**SYDNEY OLYMPIC PARK AUTHORITY  
DESIGN REVIEW PANEL  
ADVICE SHEET**

<b>Project</b>	3.1 Quest Hotel development, site 22
<b>Presentation / Review Date</b>	29 <sup>th</sup> August 2008
<b>Panel Present</b>	Peter Mould Bill Tsakalos James Weirick Darlene van der Breggen (SOPA)
<b>COI Declaration</b>	nil
<b>Also Present</b>	Steve Jensen (SOPA)
<b>Presenters</b>	Nick Tyrrell (COX Architects) Andrew Weisz (Quest) David Duncan (Aspect) (JBA)
<b>Documents made available</b>	PP presentation
<b>Inherited decisions</b>	nil
<b>Previous relevant SOPA Advice</b>	DRP Advice sheets dated 21 June 2007, 22 May 2008
<b>General Observations/ Overall Comment</b>	<p>Following on from the previous presentation, minor adjustments have been made to the building design and to its overall footprint to fit site boundaries.</p> <p>Additional material showing the proposed development in context with adjacent sites as well as a more detailed external works strategy were also presented.</p> <p>The Panel was generally supportive of the proposal but had concerns with material selection, and that the landscape strategy was 'overdesigned'.</p>

<b>Project</b>	3.1 Quest Hotel development, site 22
<b>Presentation /

Drawing Title
North/ South Elevation - Quest 22

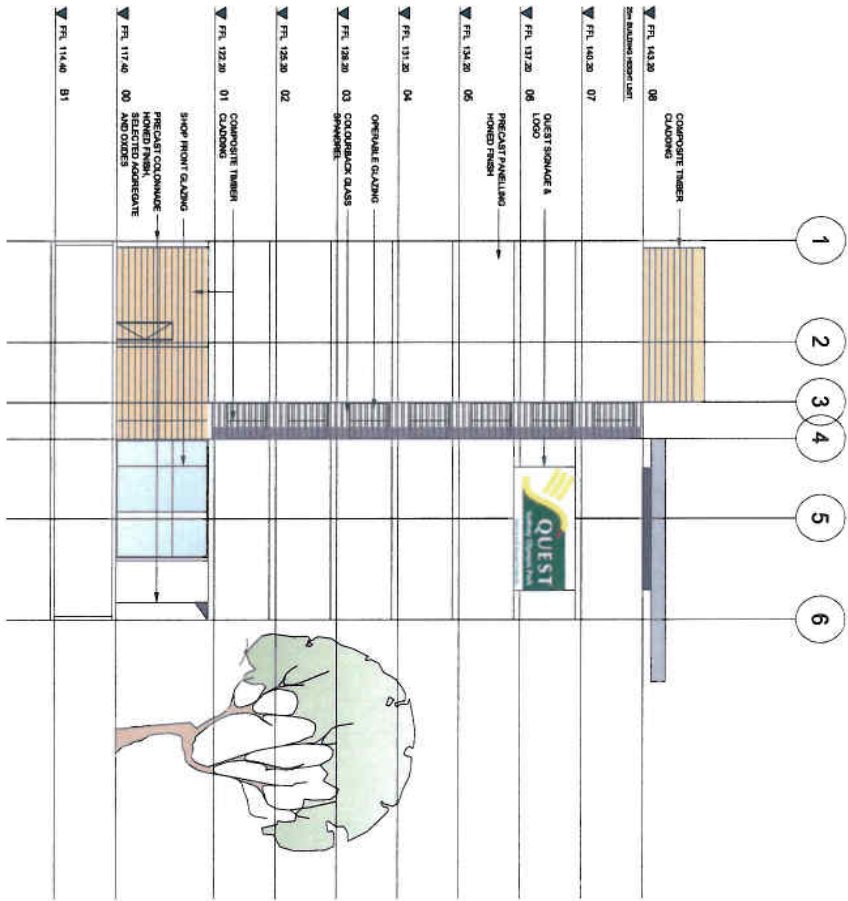
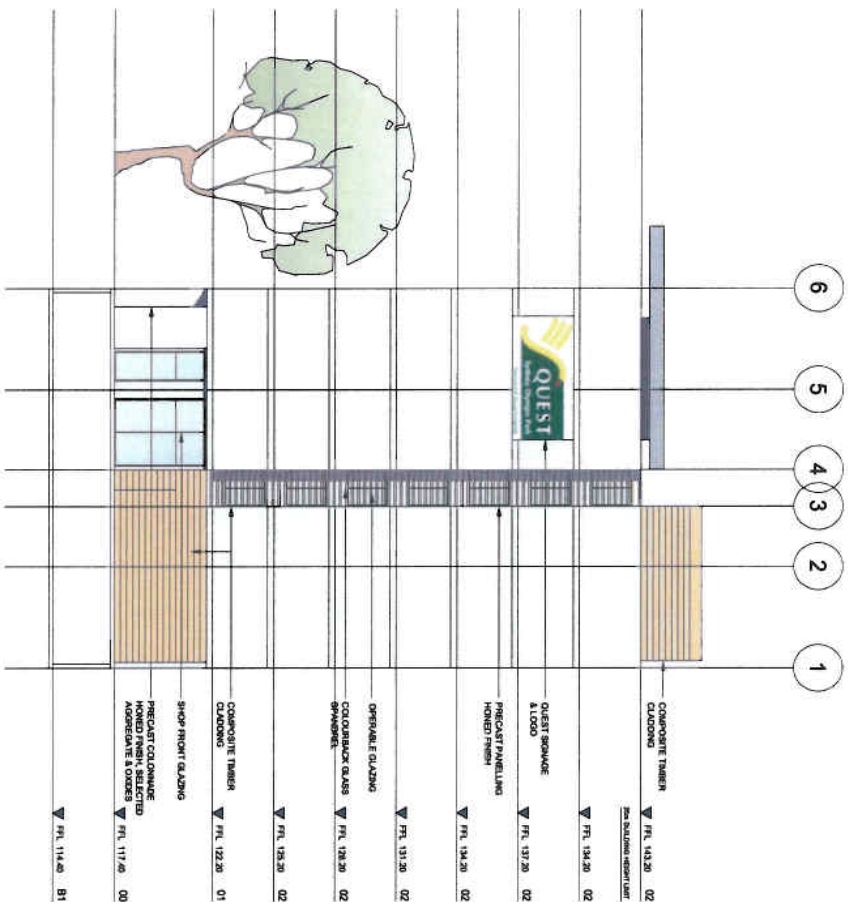
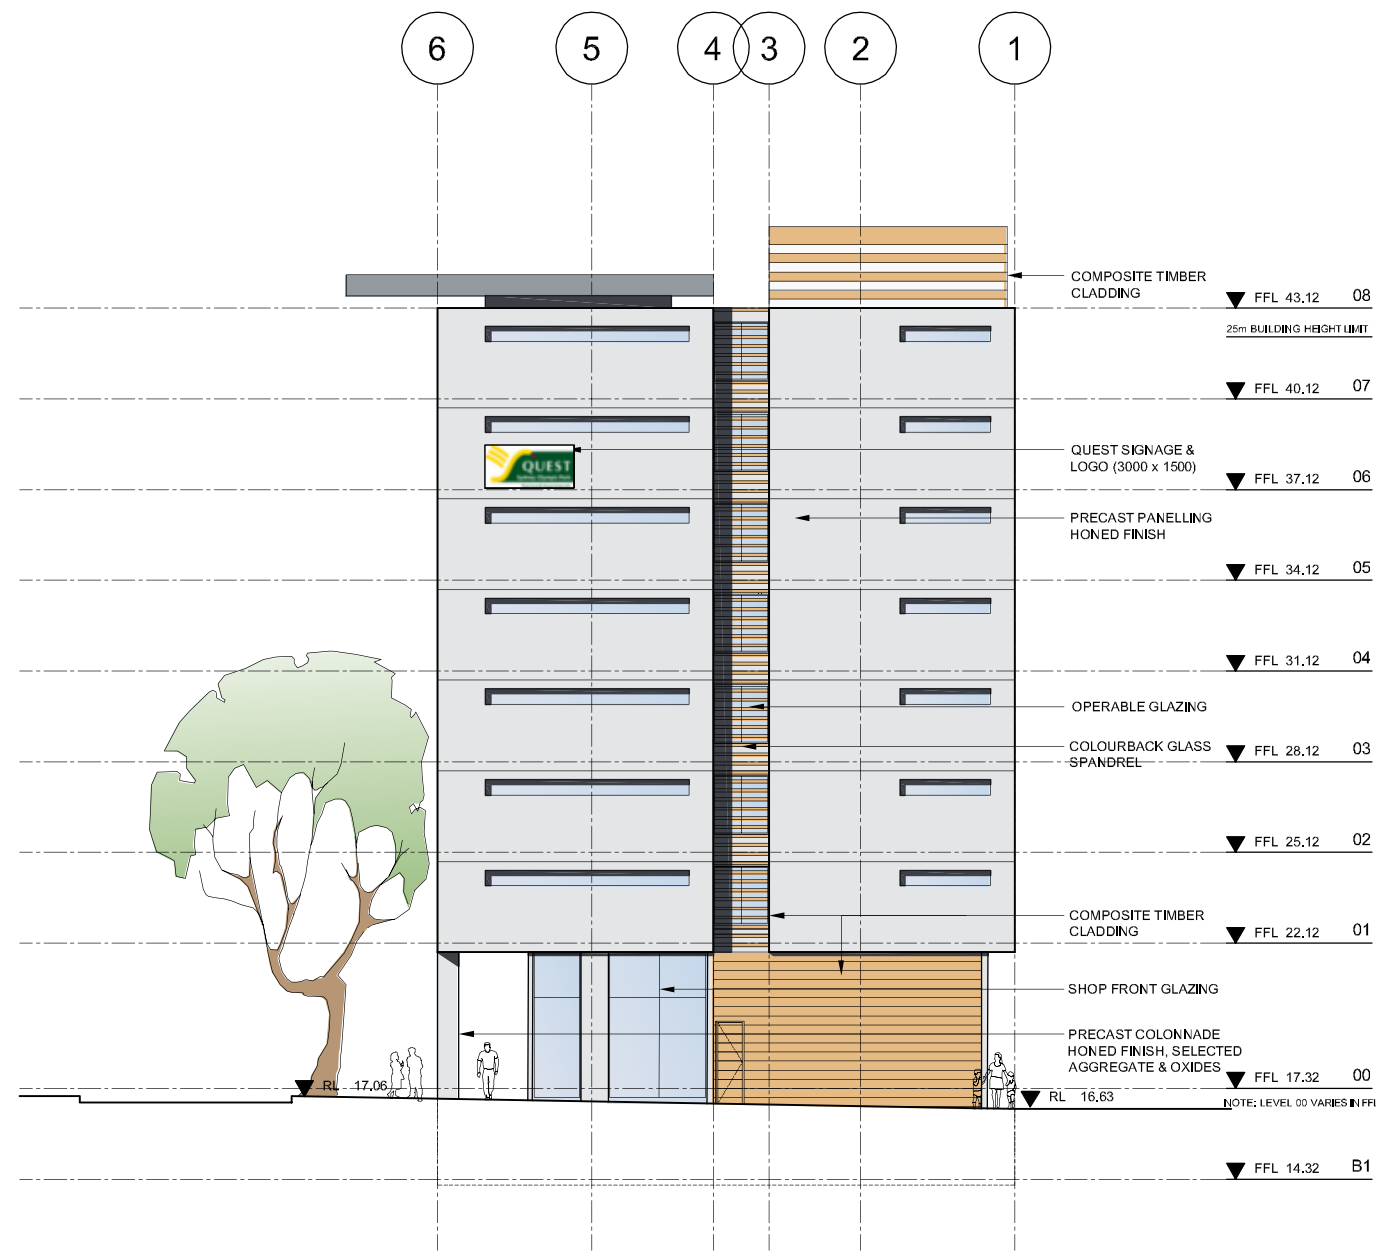
<ul style="list-style-type: none"> <li>• Amenity in the apartments generally as many apartments don't have balconies, especially those on the south-western elevation. The balconies on the Edwin Flack façade are based on an abstract composition, and could be improved through better compositional resolution allied to good amenity to all units.</li> <li>• Being residential accommodation, SEPP 65 principles, such as orientation, solar access, balconies, cross ventilation, amenity and the like, should be considered.</li> <li>• All apartments should have openable windows, and should not have to rely on air-conditioning for livability.</li> <li>• That the Panel's previous concerns relating to the treatment to the rear elevation have not been addressed ie the treatments should more closely match the amenity and composition of the front elevation .</li> <li>• The effective width of the colonnade is reduced to only 2.5m by the depth of the columns. The detailed design of the colonnade needs more development.</li> <li>• The proposed shared ways at either end of the building, should be capable of becoming streets connecting to the Carter Street precinct when it develops. This proposal for fully paved spaces, is not a desirable public domain, and needs to be reconsidered</li> <li>• The amenity of the through site link adjacent the foyer appears to be bleak and potentially detracts from the cross streets mentioned above.</li> </ul>

<b>Matters for consideration</b>	See above.
<b>Recommended Supporting Action</b>	<p>That SOPA requires the application to adequately address the above design issues. The proposed revisions to the building envelope be shown in its broader context, including site plans and full street and lane elevations and sections.</p> <p>That SOPA considers upgrading the adjacent shared ways to cross streets.</p>
<b>Circulation of Advice</b>	SOPA and proponent

Public domain

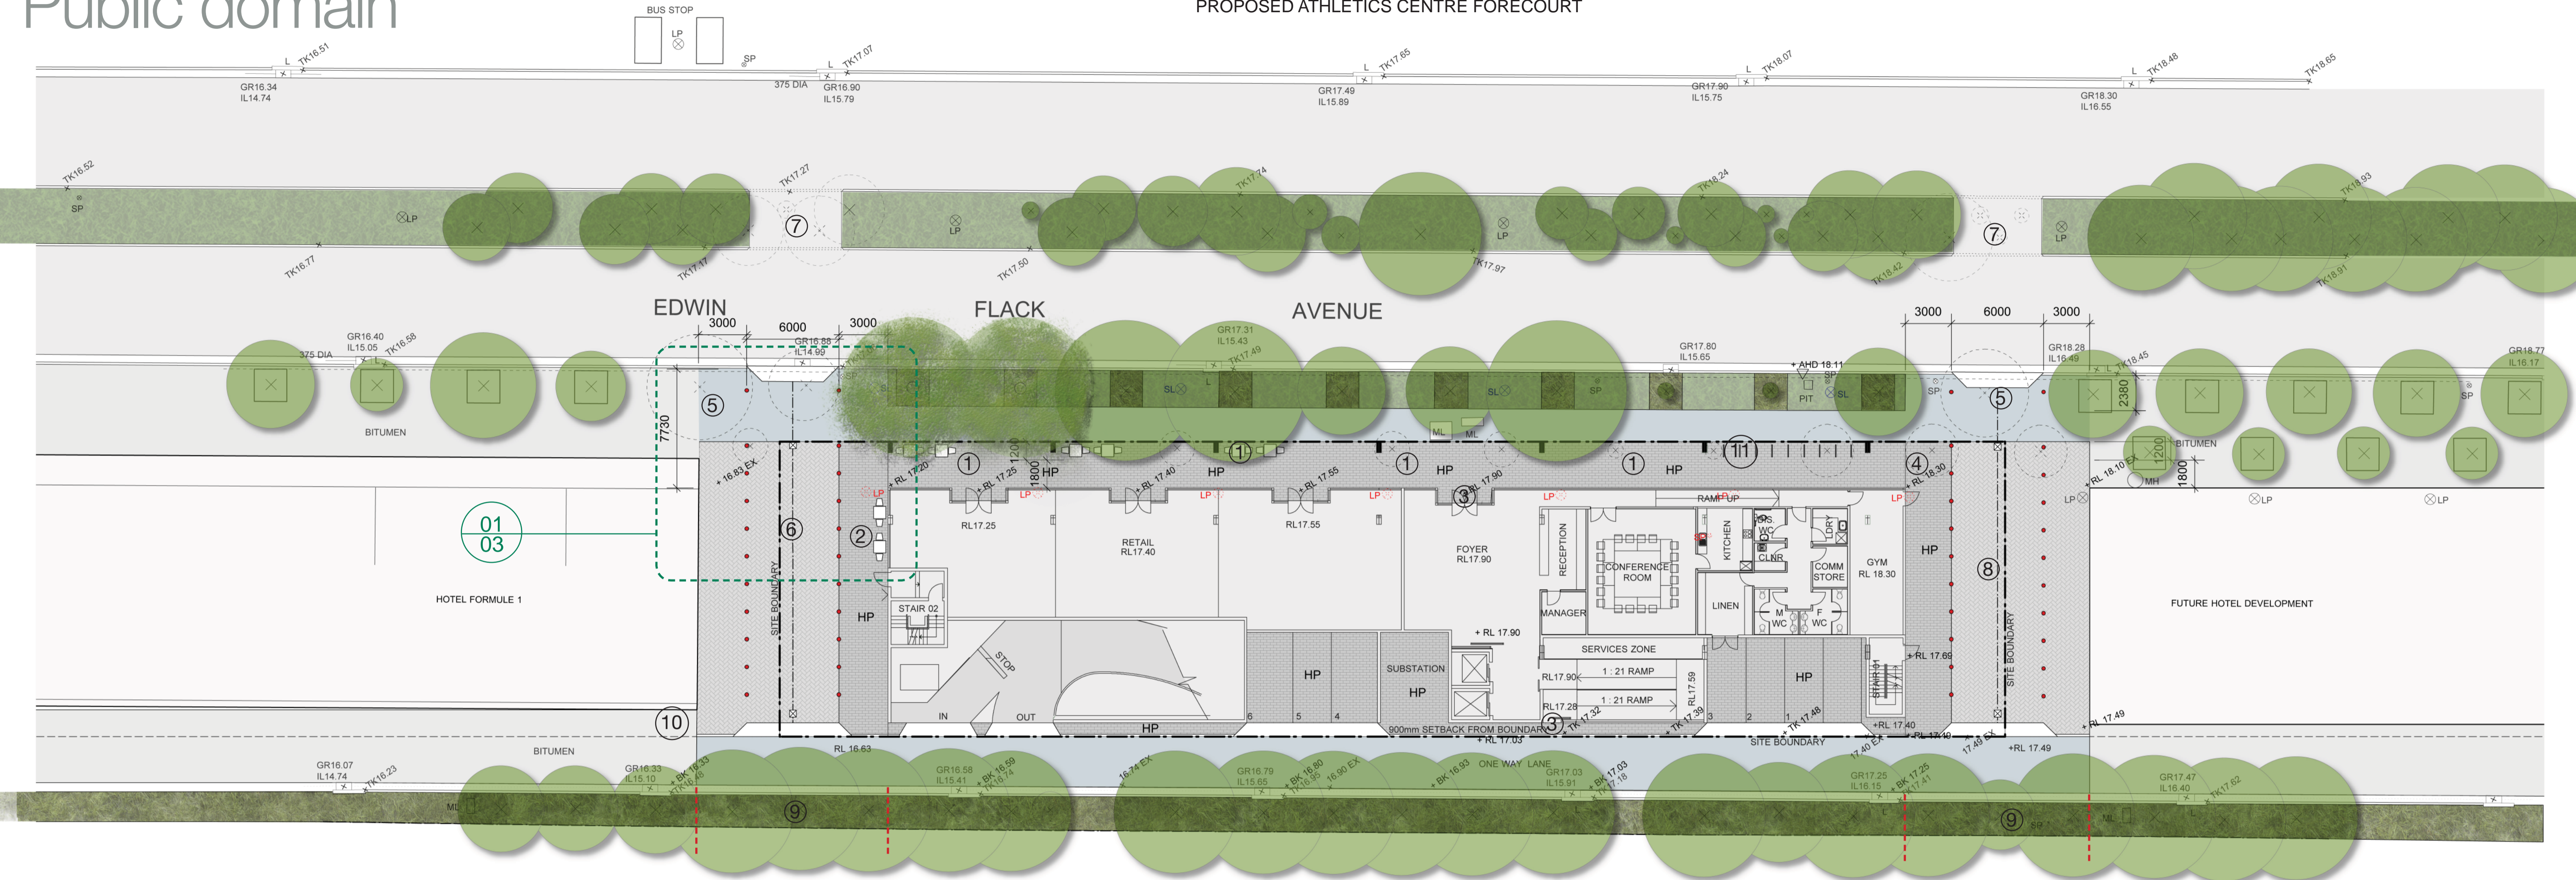
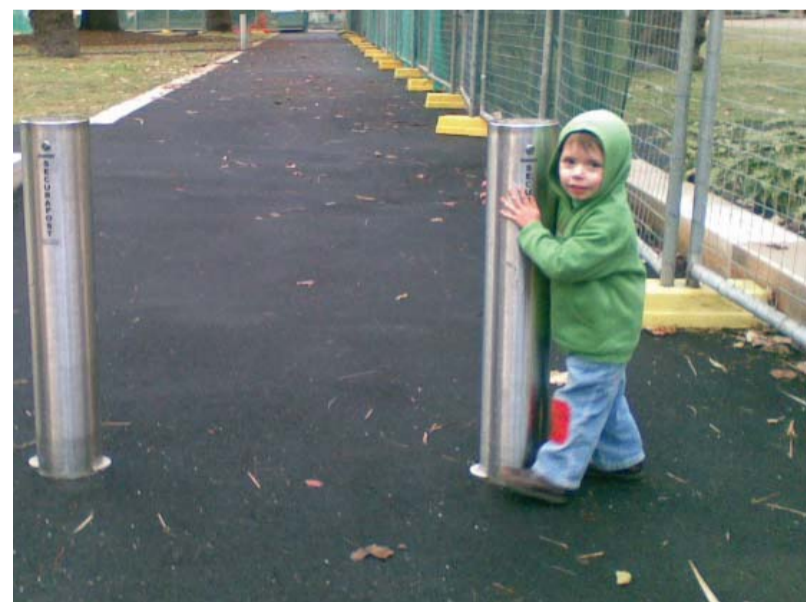
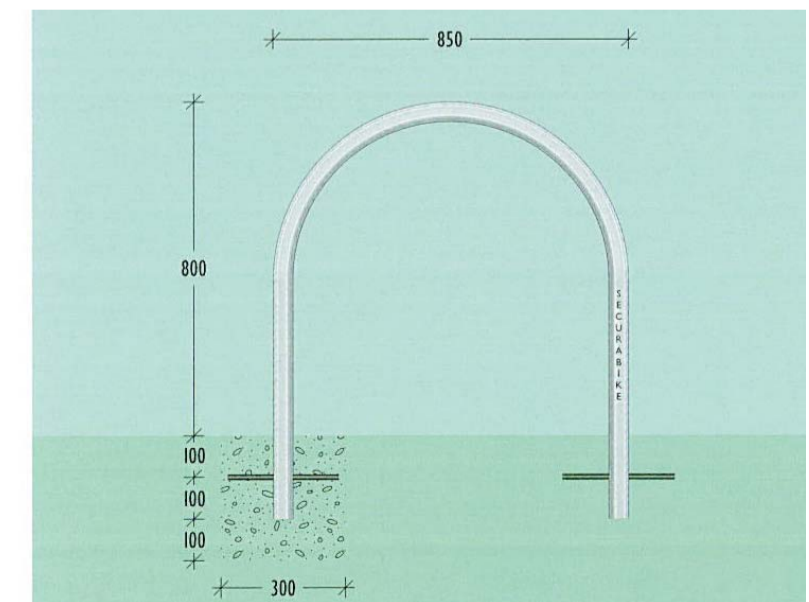
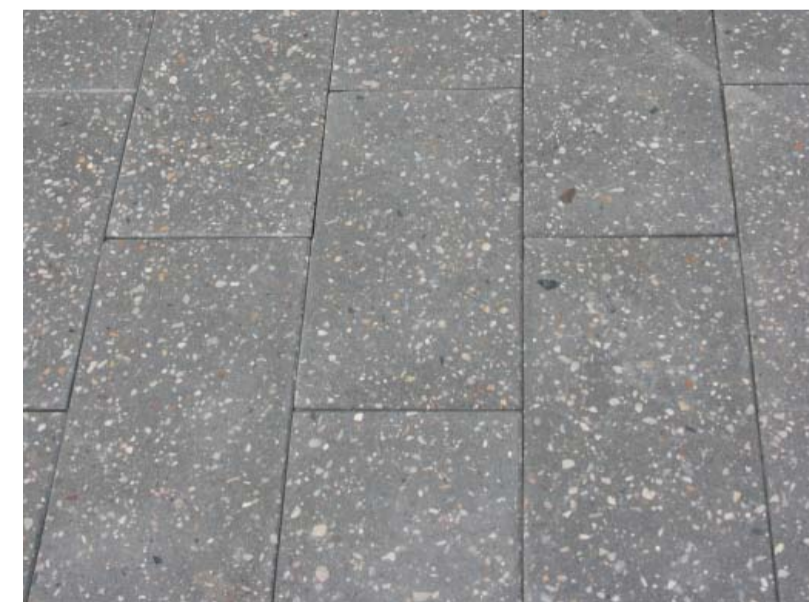
<b>Positives</b>	<ul style="list-style-type: none"> <li>• comprehensive external works proposal that extends beyond site boundaries and coordinates with adjacent existing and future developments.</li> <li>• Windows in the end elevations improve amenity to the end units and reduce the bleakness of these elevations.</li> <li>• slab levels for most of the ground floor have been adjusted to match adjacent natural ground levels.</li> <li>• Design objective to give amenity, human scale and interest to the colonnade is strongly supported</li> </ul>
<b>Issues</b>	<p>The DRP had the following concerns:</p> <ul style="list-style-type: none"> <li>• Use of timber in a thin veneered panel, is a cosmetic treatment.</li> <li>• Landscape treatments along the colonnade are overdesigned at present and create a barrier between the colonnade and the footpath, and may privatise the colonnade.</li> <li>• Strategy required for the appropriate illumination of the colonnade</li> <li>• the function of adjacent shared ways has not been resolved in relation to the broader context of traffic and pedestrian movements.</li> </ul>

<ul style="list-style-type: none"> <li>• Bollards along rear service road, in lieu of a kerbed edge.</li> </ul>
<b>Matters for consideration</b>	<p>The panel recommended that:</p> <ul style="list-style-type: none"> <li>• Higher quality materials be used externally, ie real timbers instead of composite veneers</li> <li>• Reconsider planter boxes and seating along the colonnade; consider re-locating seating to the verge, designed as an integrated landscape element, with or without the protective fence</li> <li>• Reconsider the landscape components of the scheme as a resolved combination of 'green façade' planter boxes and streetscape elements</li> <li>• Reconsider requirement for asphalt paving along the colonnades, unit paving is preferred.</li> <li>• Good quality lighting to the colonnade, with colour temperature and lighting levels that welcome public use of the space</li> <li>• A kerbed edge be used along the rear lane to match the adjacent Formule 1 hotel.</li> <li>• Paving and street furniture in the shared ways should be suited to the function of these spaces which needs to be clarified in terms of pedestrian / vehicle priority.</li> </ul>

<b>Recommended Supporting Action</b>	That SOPA resolves the design functionality of the rear laneway and the adjacent shared ways.
<b>Circulation of Advice</b>	SOPA and proponent
